Reference: Tijeras Club Townhouses

Subject: Tijeras Club Townhouses, FHA File No. 530,
Albuquerque, New Mexico

Our review of the neighborhood grading and drainage plan for the subject subdivision reveals that it is not acceptable. The plan proposes "ponding areas" on a number of the lots as close as five (5) feet from the buildings. FHA's requirement is that no water be ponded within fifteen (15) feet of the structure. In addition, the soils report for the subject subdivision recommends that positive surface water drainage be maintained and that the soils at and below the foundation elevations be kept dry.

Site & Grading Plans for
TITERAS CLUB
TOWNHOUSES
FIG. 5

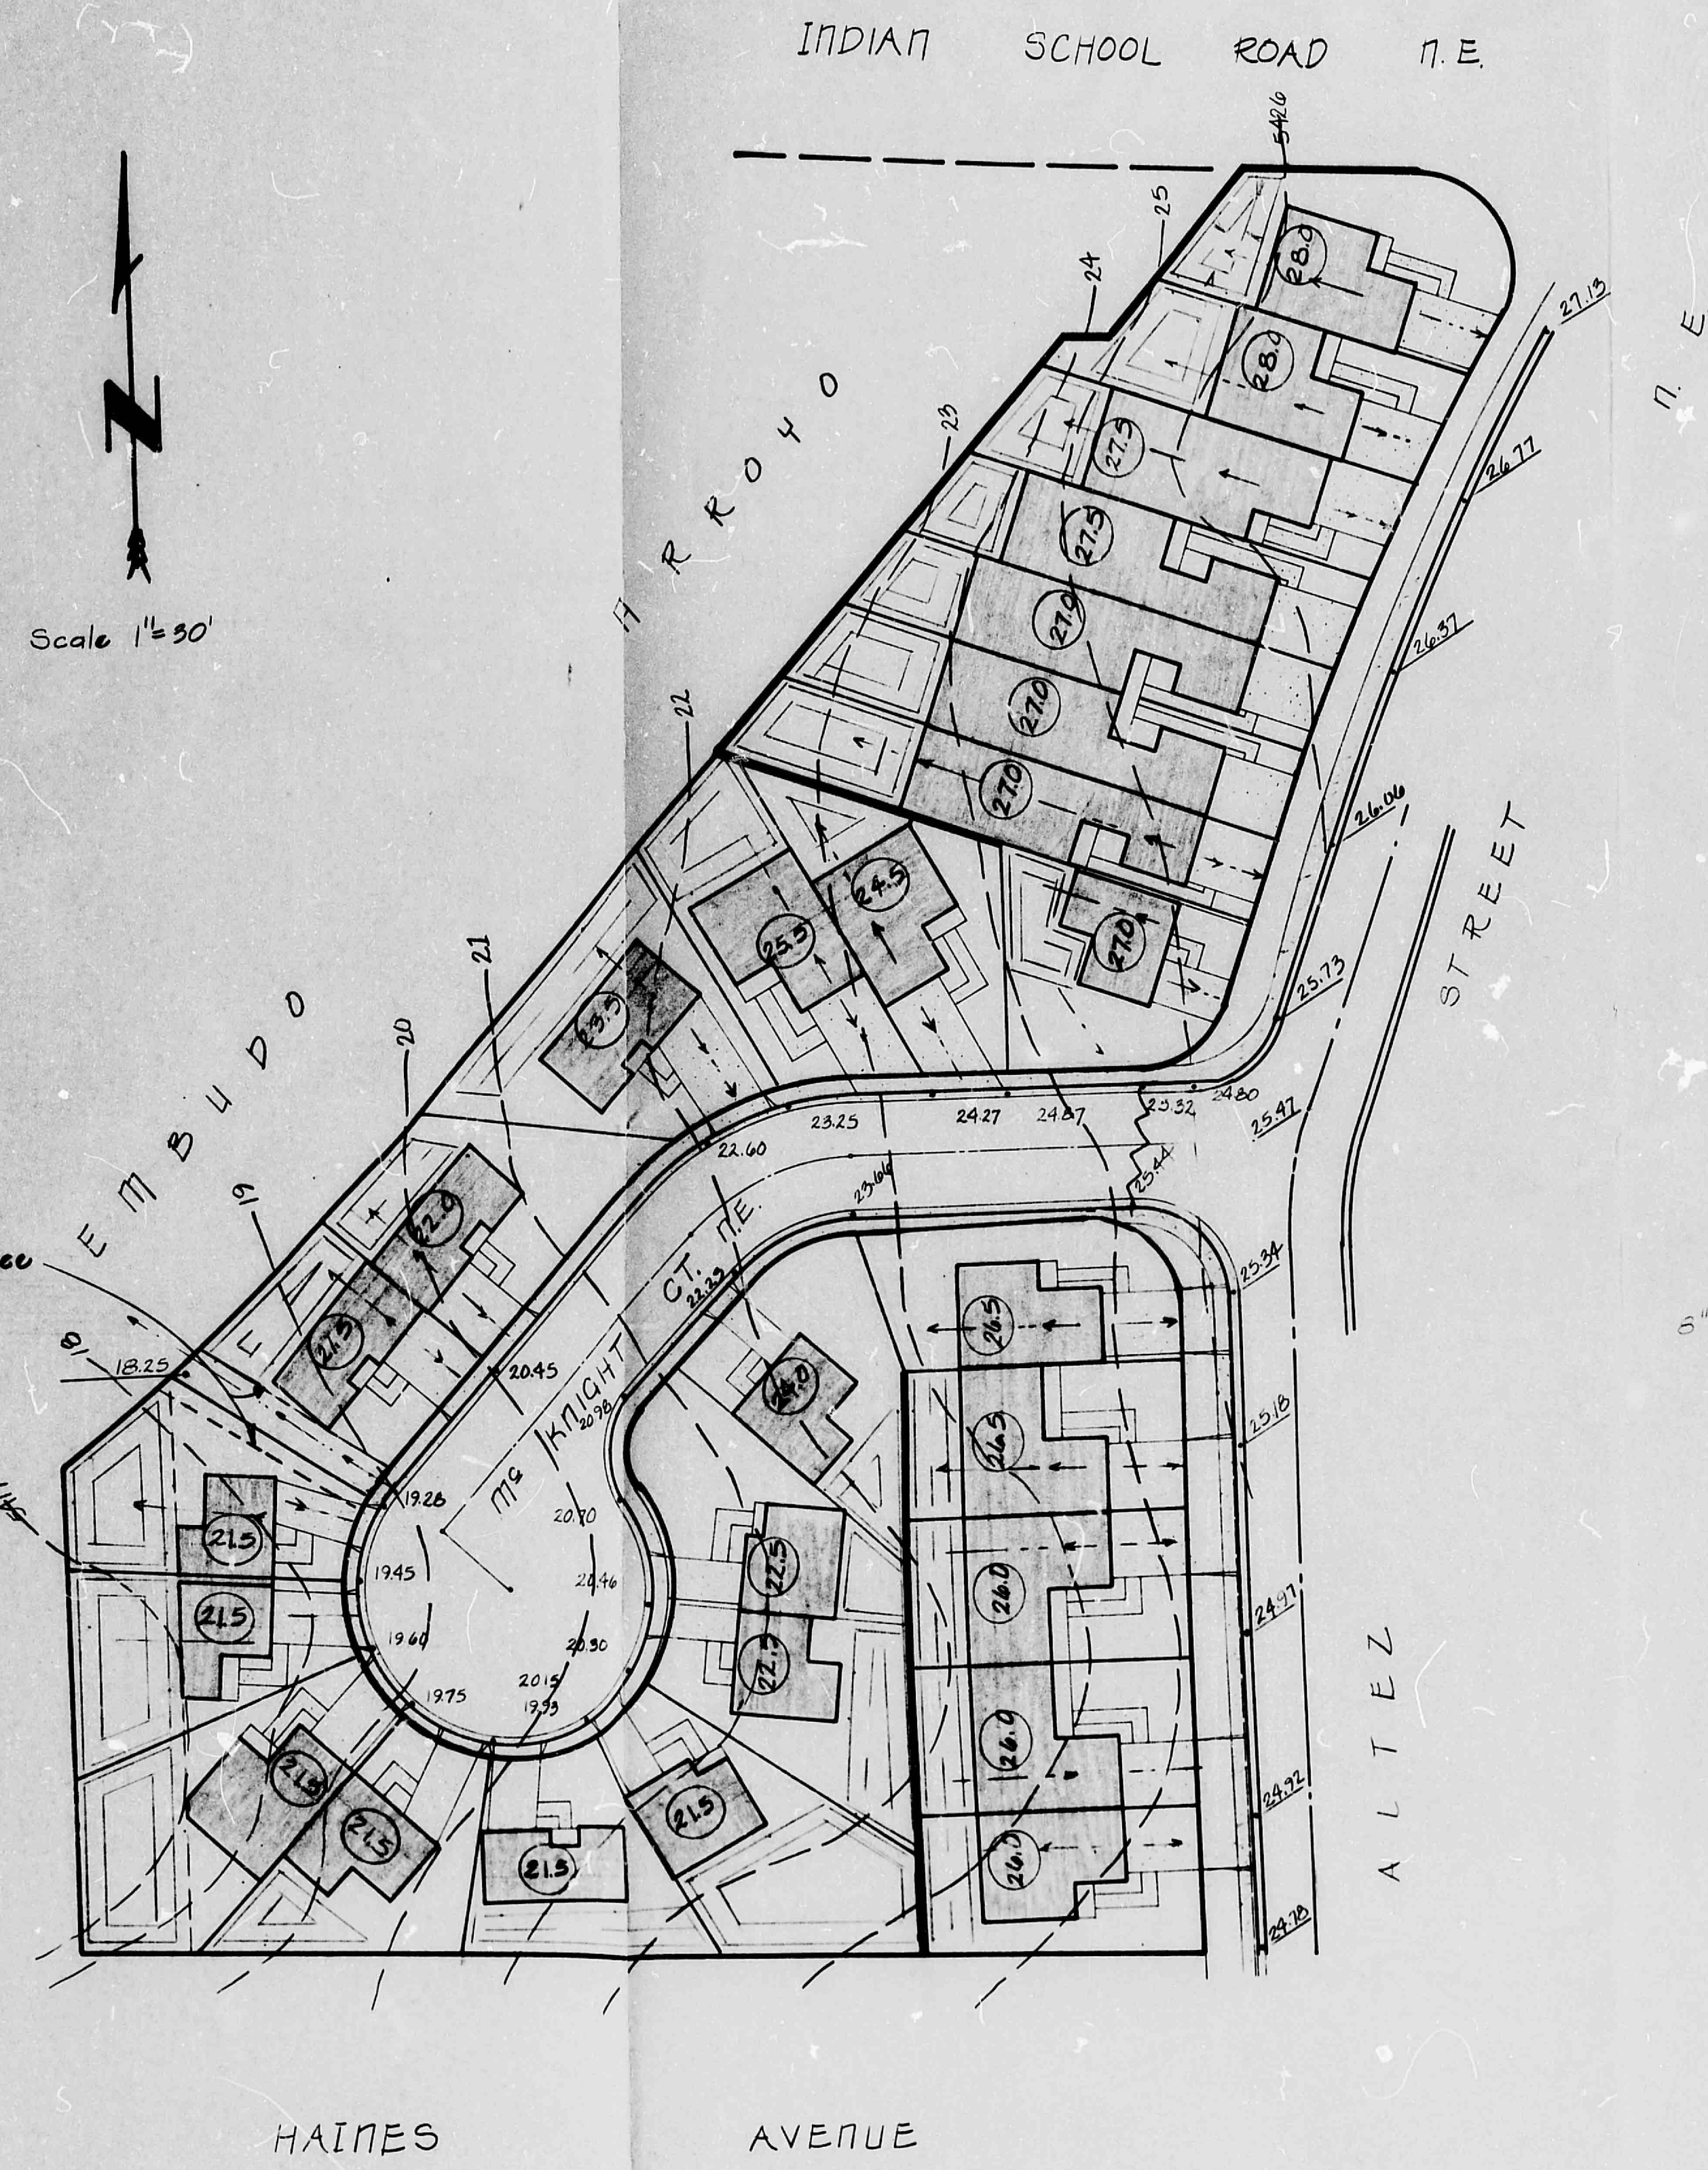
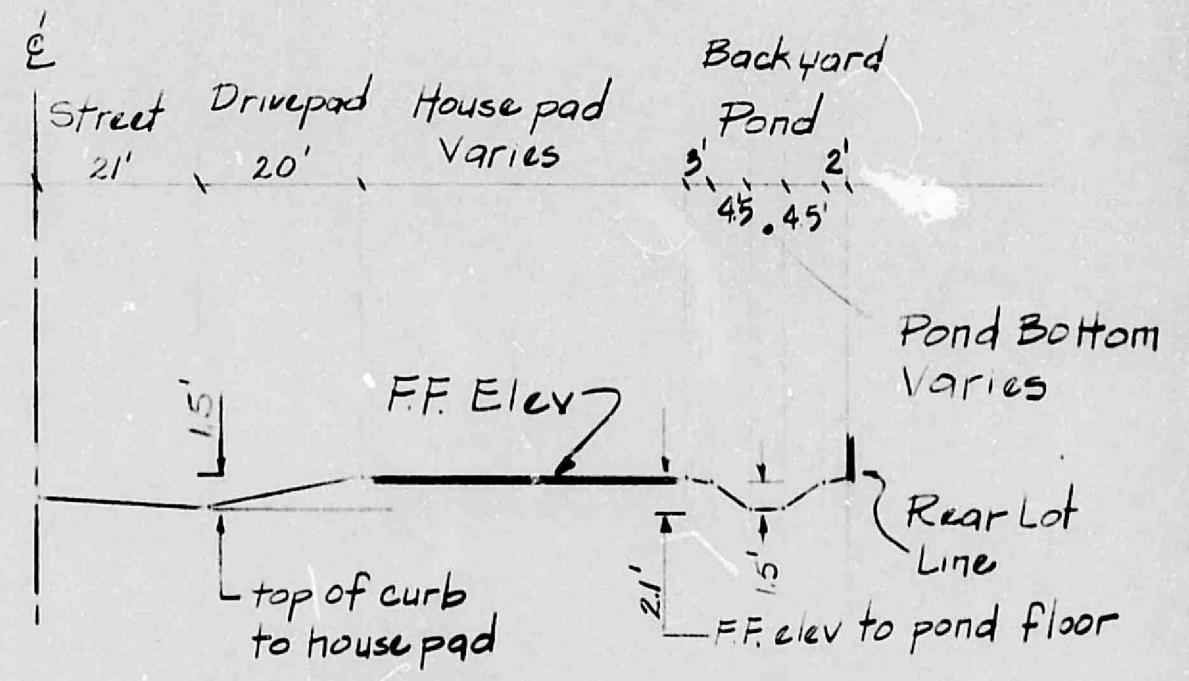
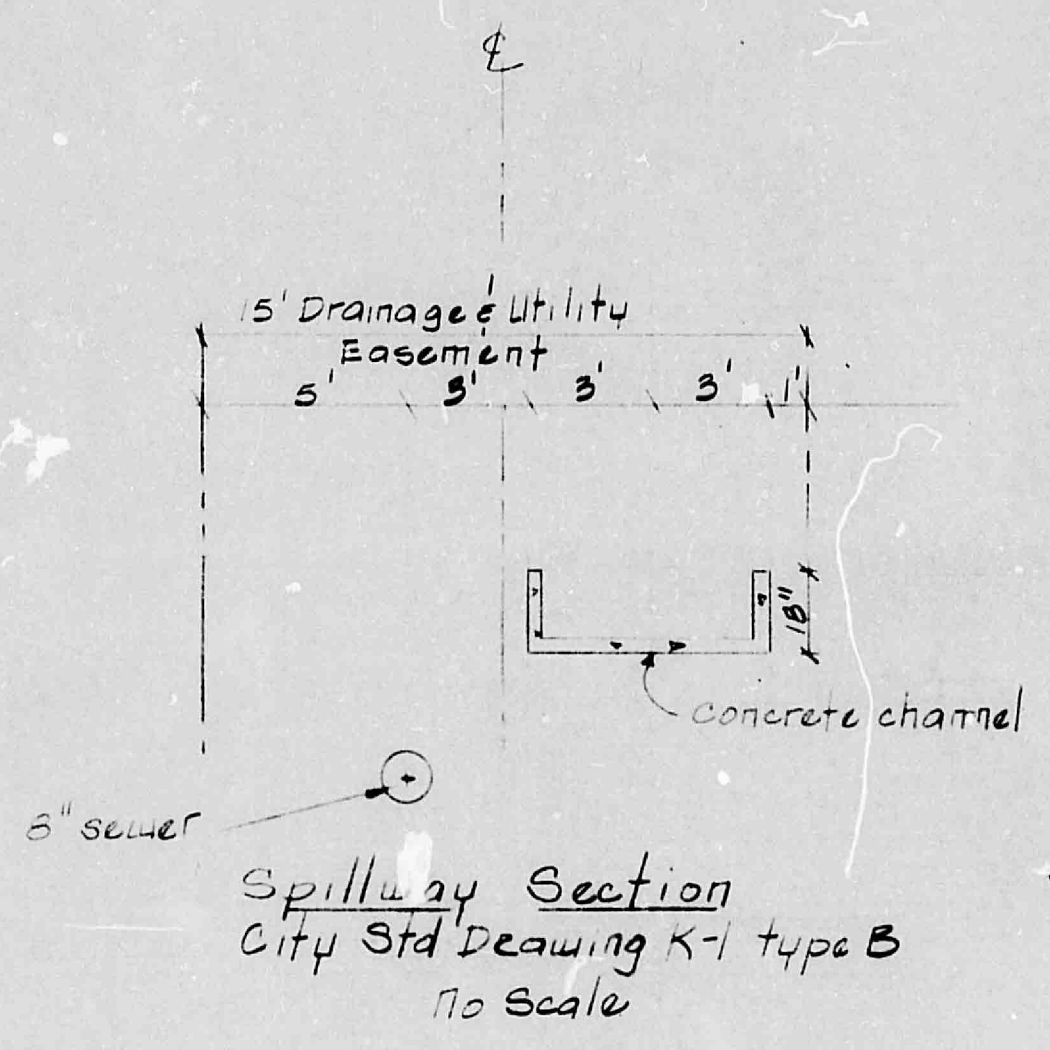
Due to the size of lot in this development and the placement of the buildings, it may be necessary to find an alternative to ponding in order to maintain the structural integrity of the proposed units.
